Ref: Holcim Expansion Submission Letter01

RE: Dubbo Quarry Continuation Project (SSD 10417) Notice of Exhibition – Submission Letter

Maas Group Properties provides the following submission letter to the Dubbo Quarry Continuation Project known as State Significant Development Application number: SSD 10417. The matters of concern are detailed as follows:

FIGURE NUMBER:	10
PROJECT:	DUBBO QUARRY - FLOOD STUDY
PROJECT NUMBER:	190036
SCENARIO:	PROPOSED CONDITIONS
EVENT:	20% AEP
TITLE: FLOOD IMPACT

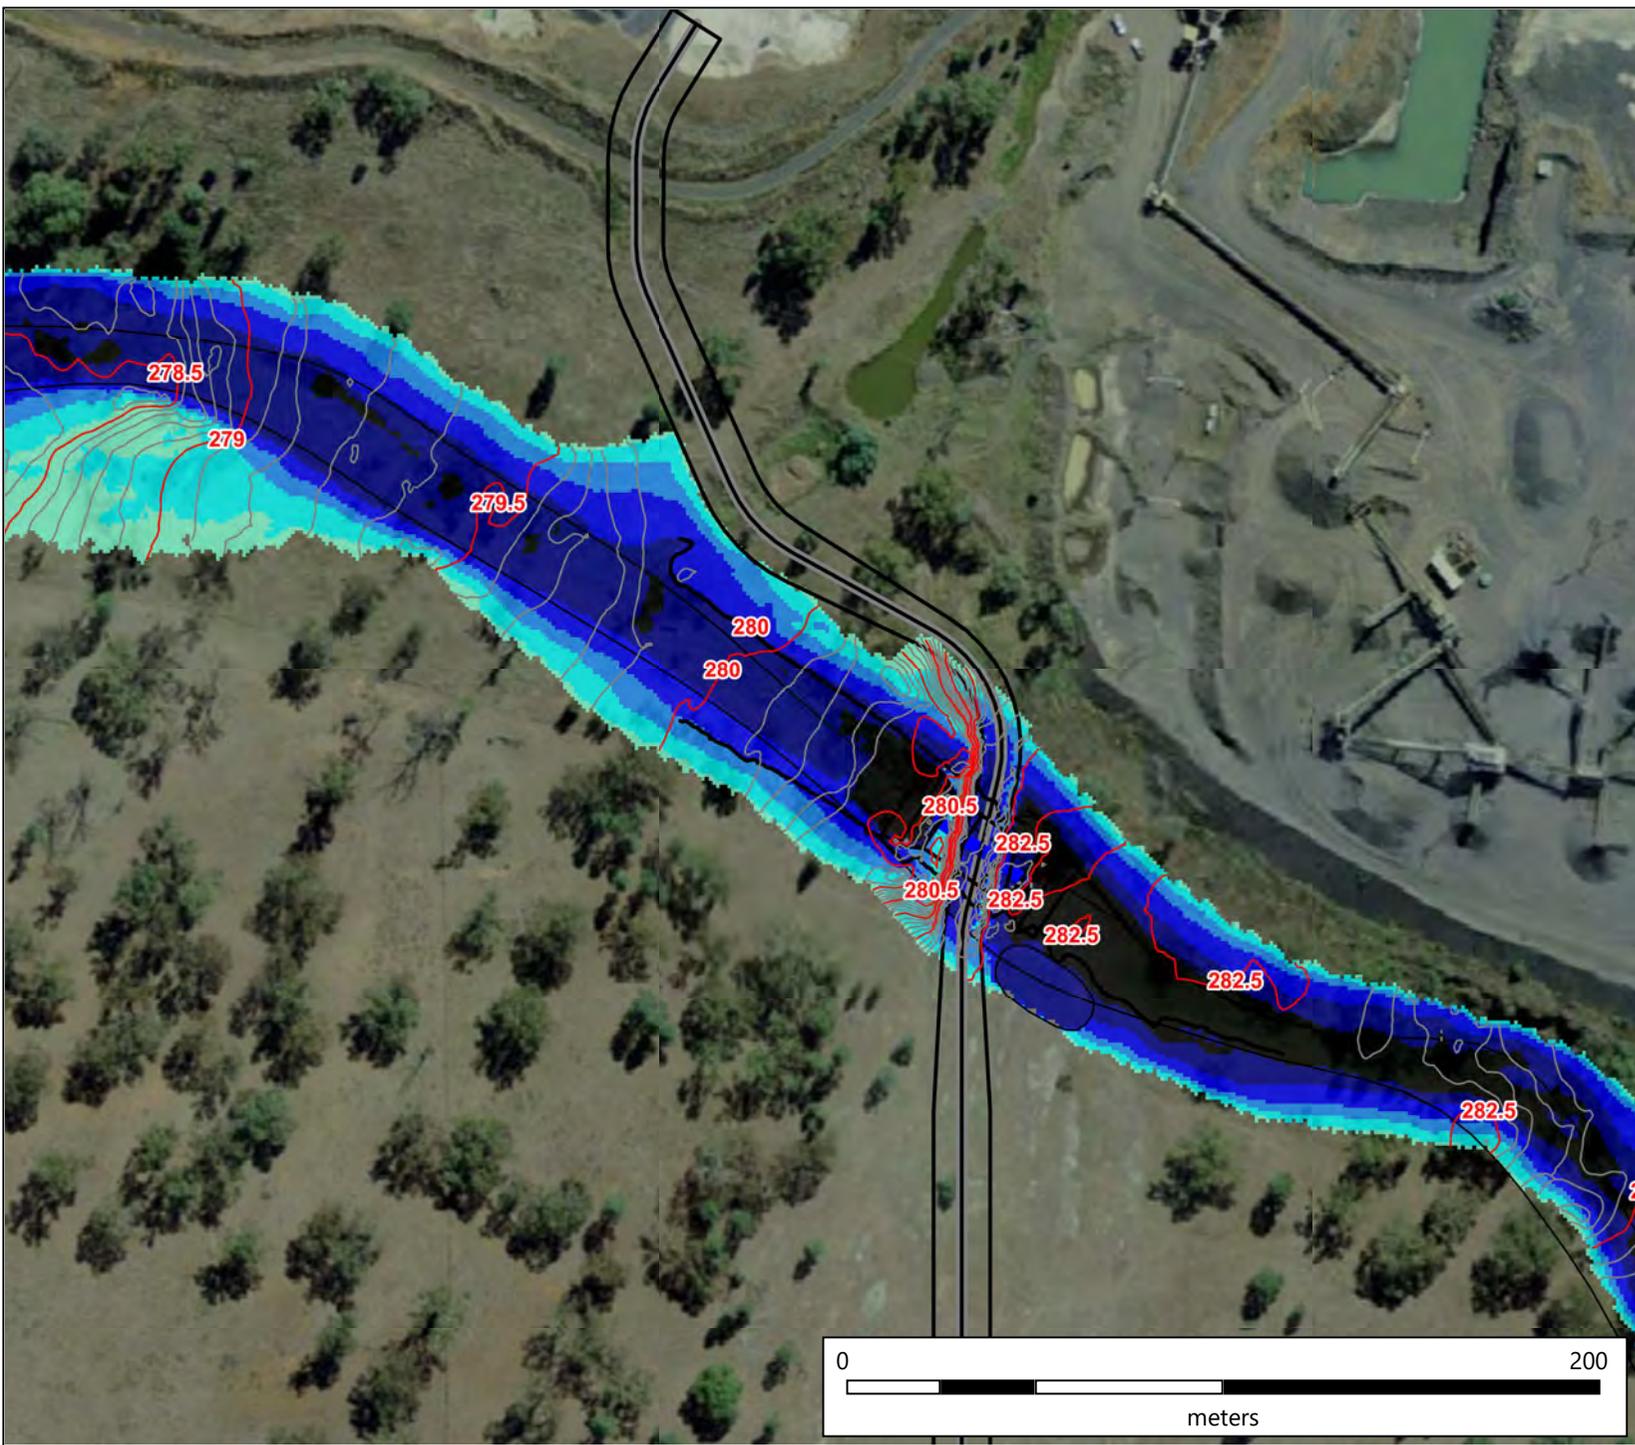
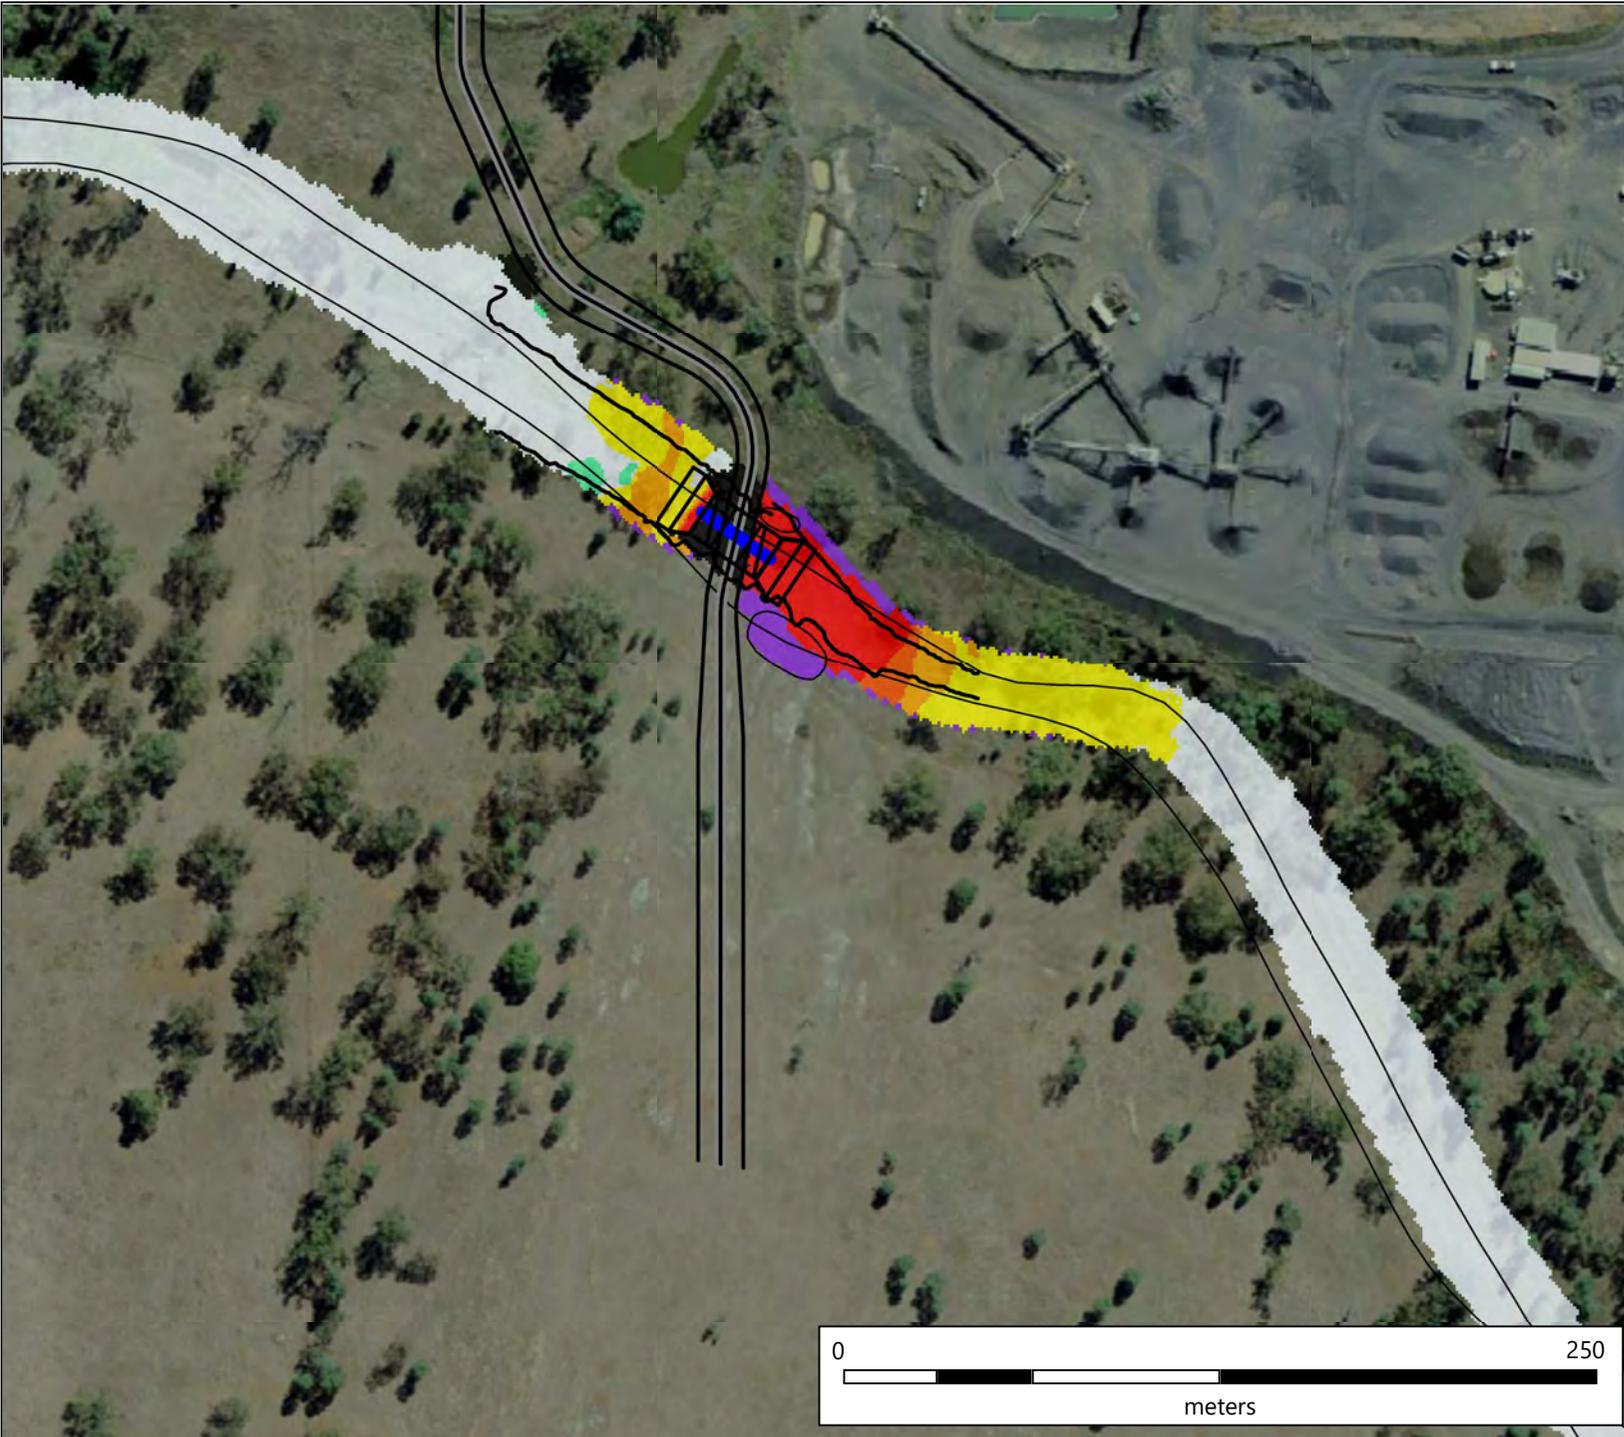
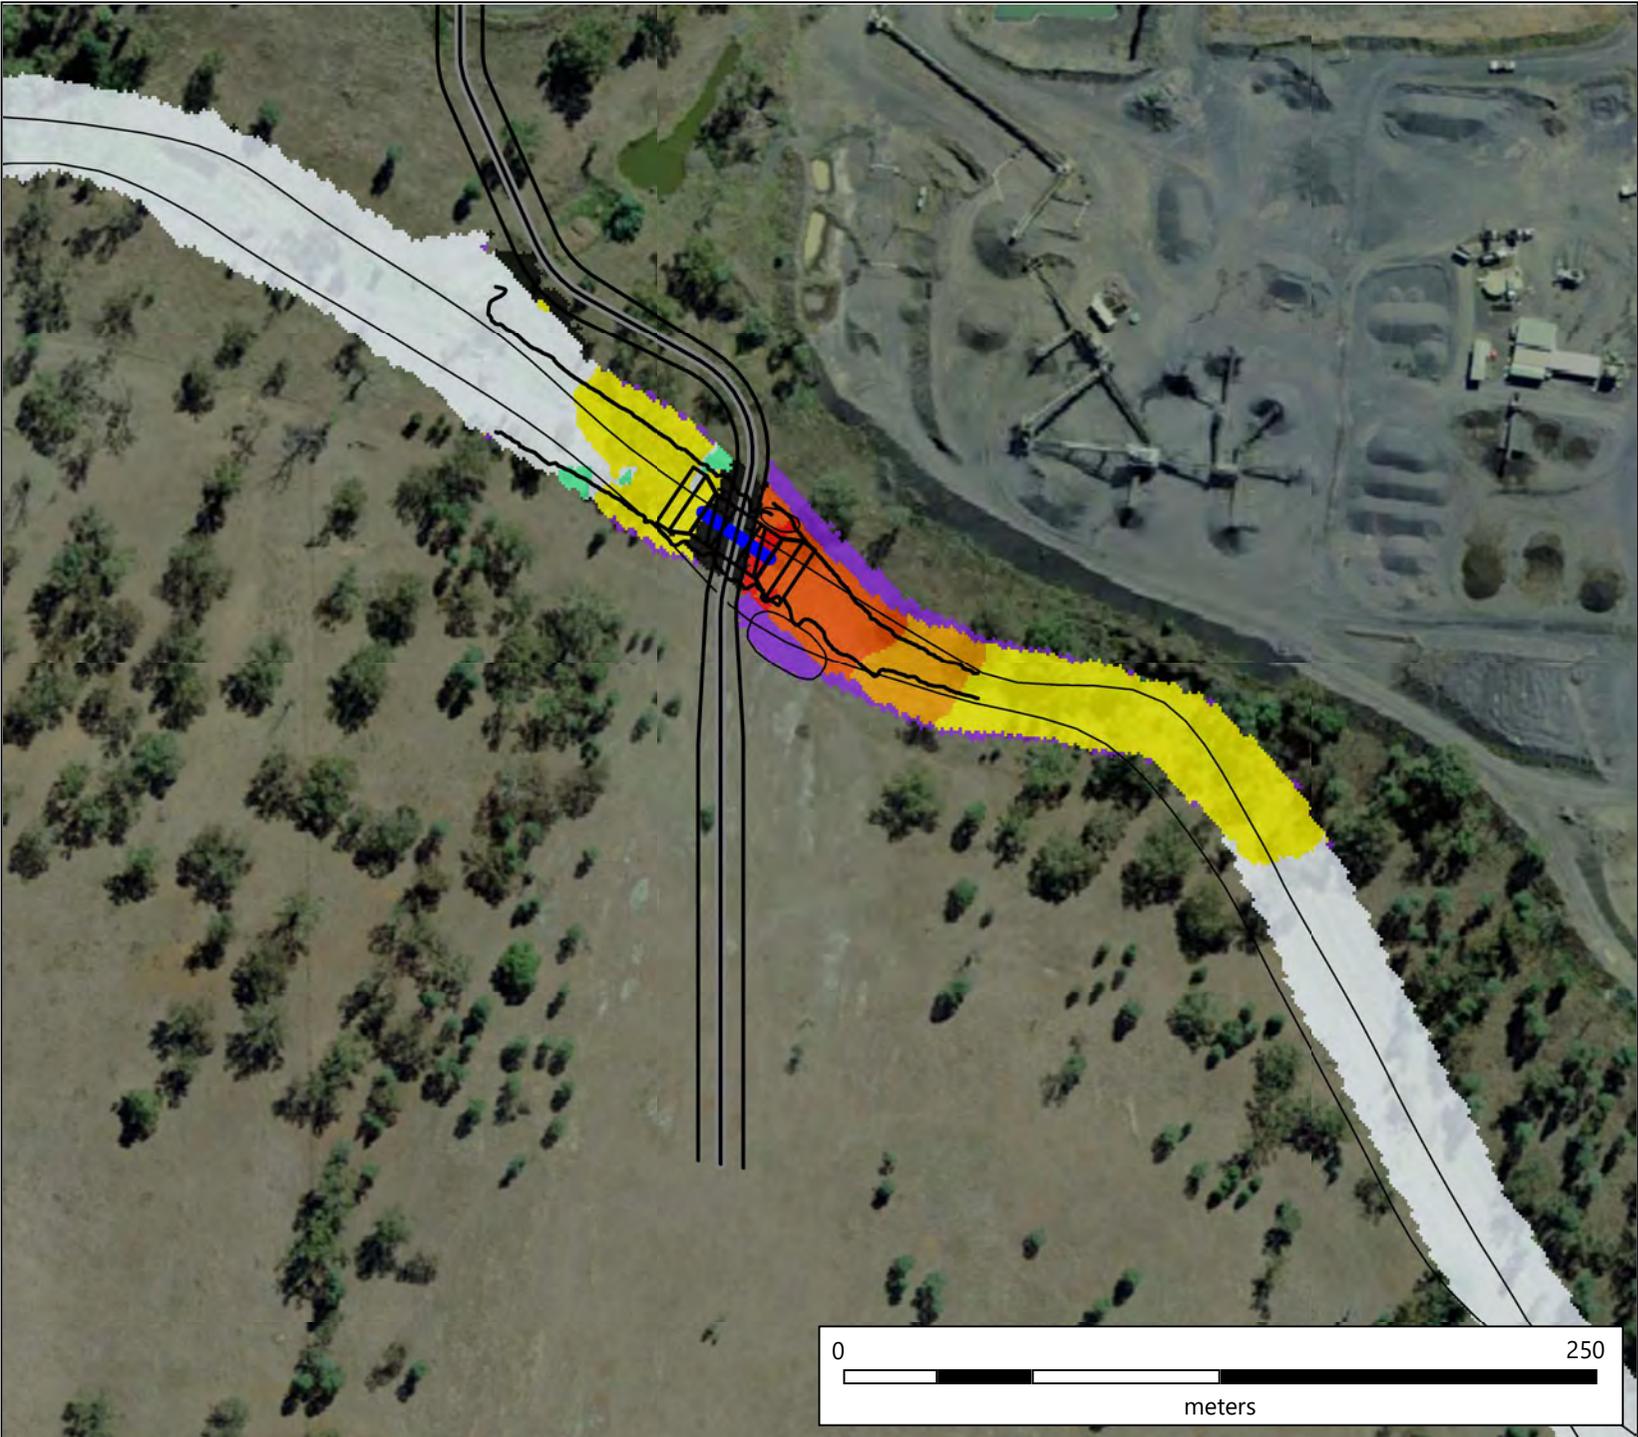
It is recommended that additional clarification be sought around the level of flood affectation. Whether the proposed works will exacerbate flood affectation during a storm even or whether the SEA has an appropriate flood evacuation strategy in place access to the southern side of the quarry is via a light vehicle access road.

SITE ARRANGEMENT
SCALE 1:10,000

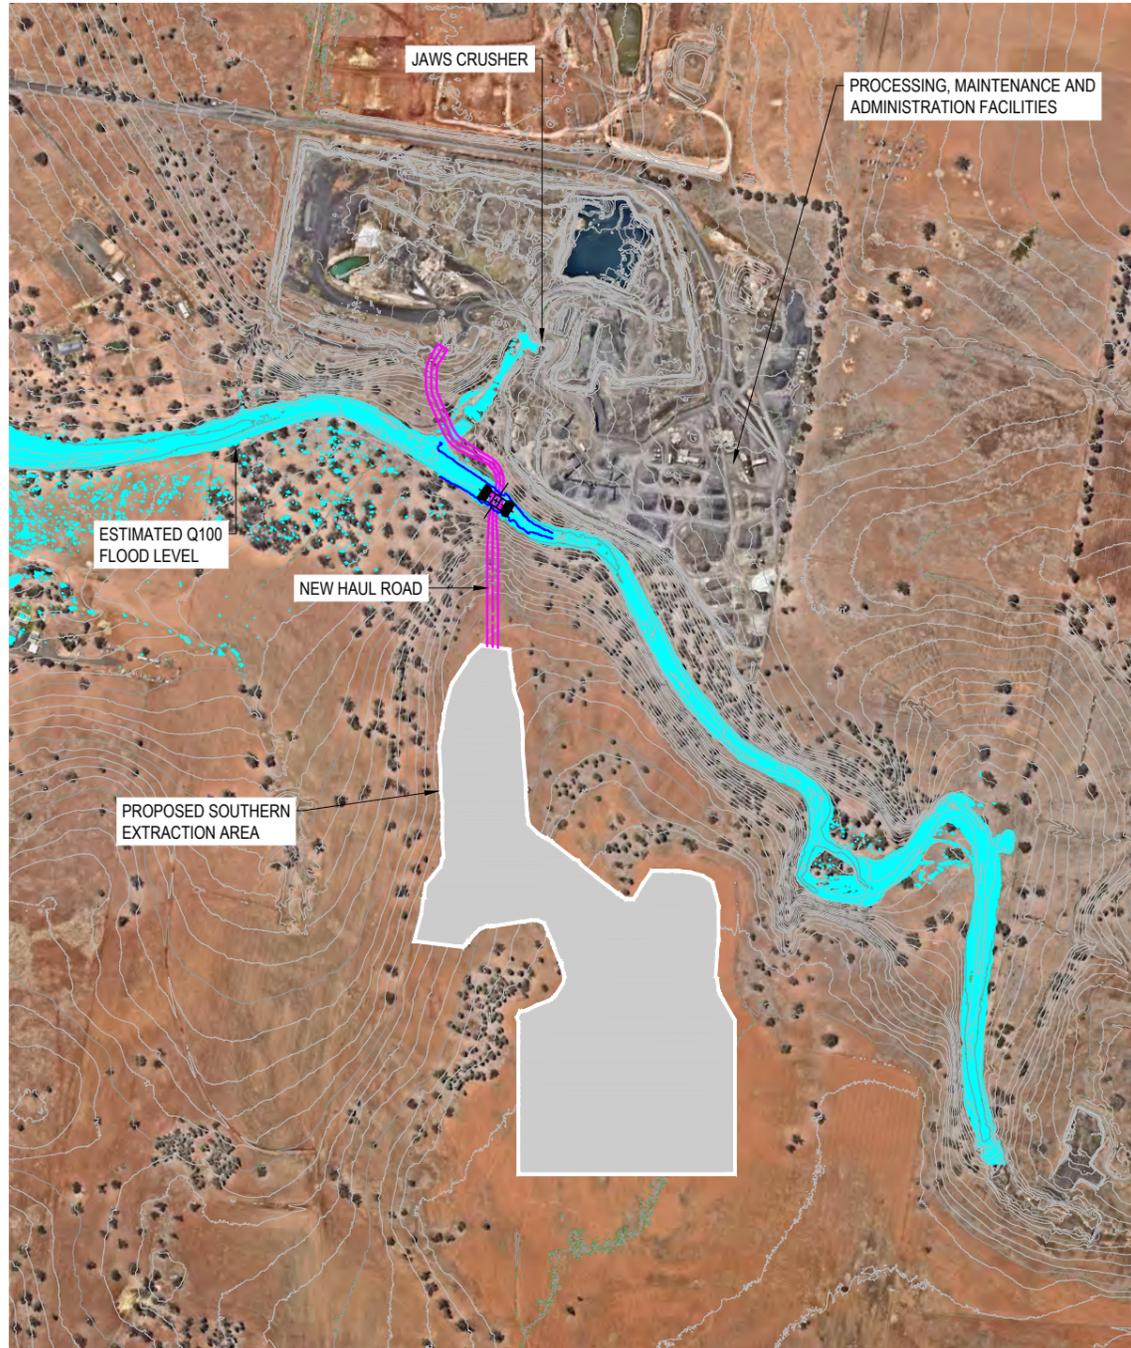
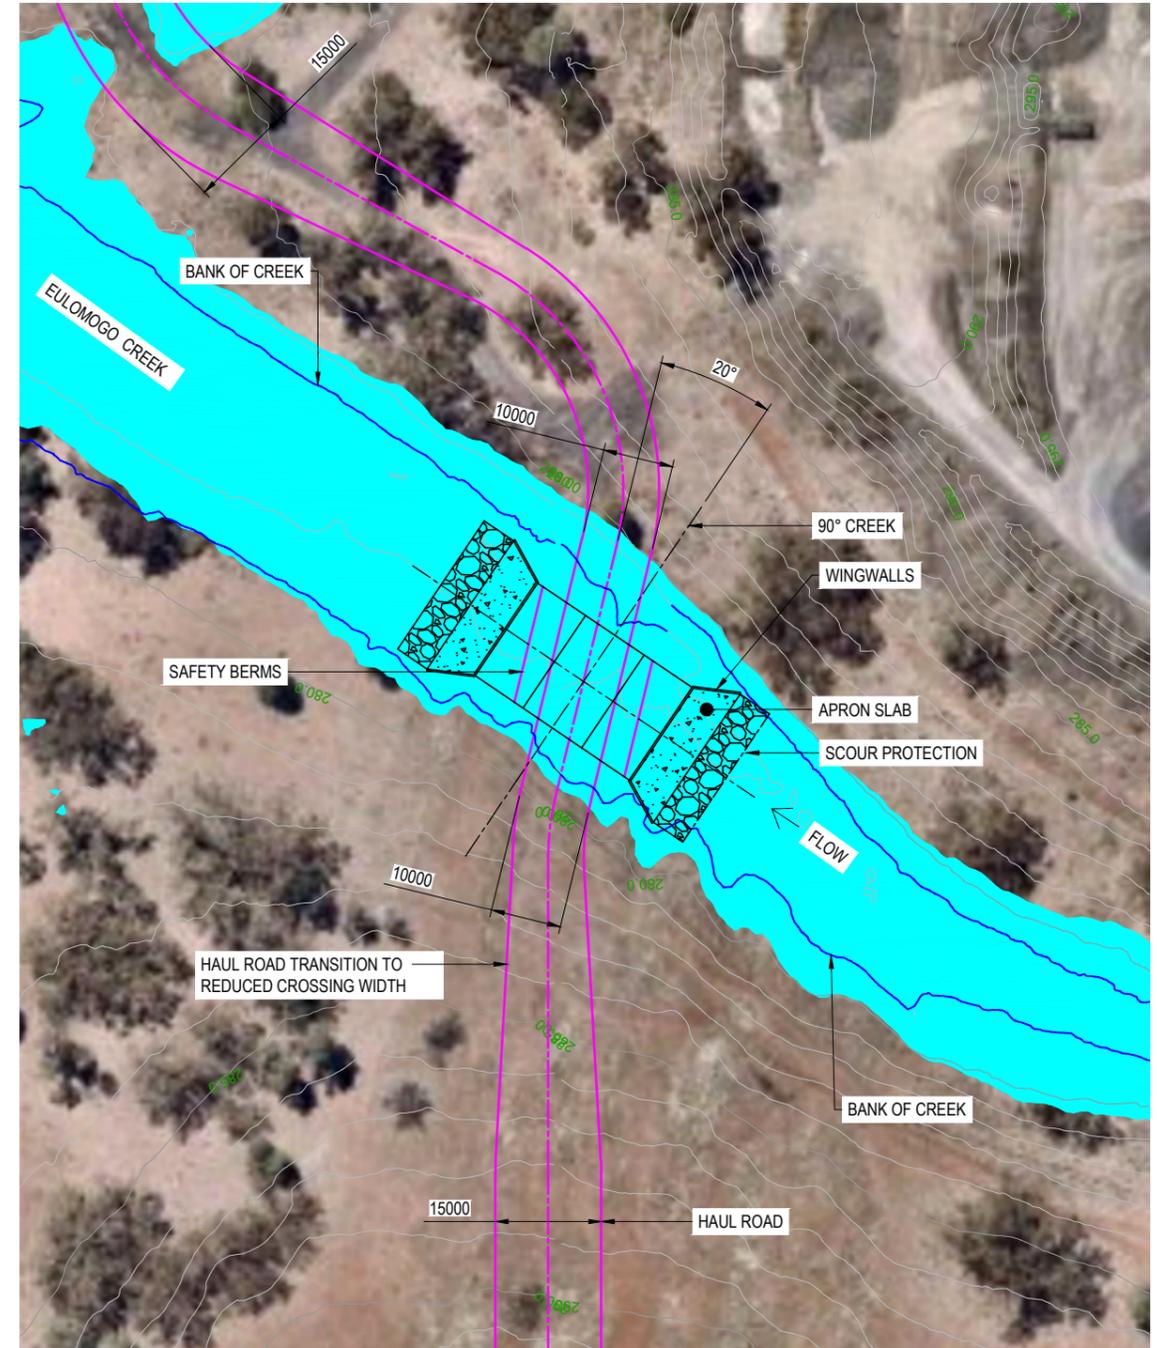
The proposal seeks approval for an internal crossing over the Eulomogo Creek to construct the Southern Extraction Area (SEA). The Eulomogo Creek runs through the project area with its associated second and first order ephemeral water courses. Southlakes Estate, a dairy and the City of Dubbo including potable water infrastructure are directly downstream of the site and its proposed crossing therefore any potential risk of potentially contaminating activities should be carefully considered as adverse impact would not only cause environmental harm but also put at risk existing and future residences and its occupants. It is also common knowledge and known that the existing quarry has intercepted groundwater and upon occasion discharges intercepted water to Eulomogo Creek.

It is recommended that the proposal detail the creeks disturbance area and address sediment and erosion control, water quality, onsite haulage procedures both onsite and across the water course including contamination and waste management measures. Additionally, clarification is sought around the points of discharge to the environment and whether there will be pollution control measures and an ongoing management system.
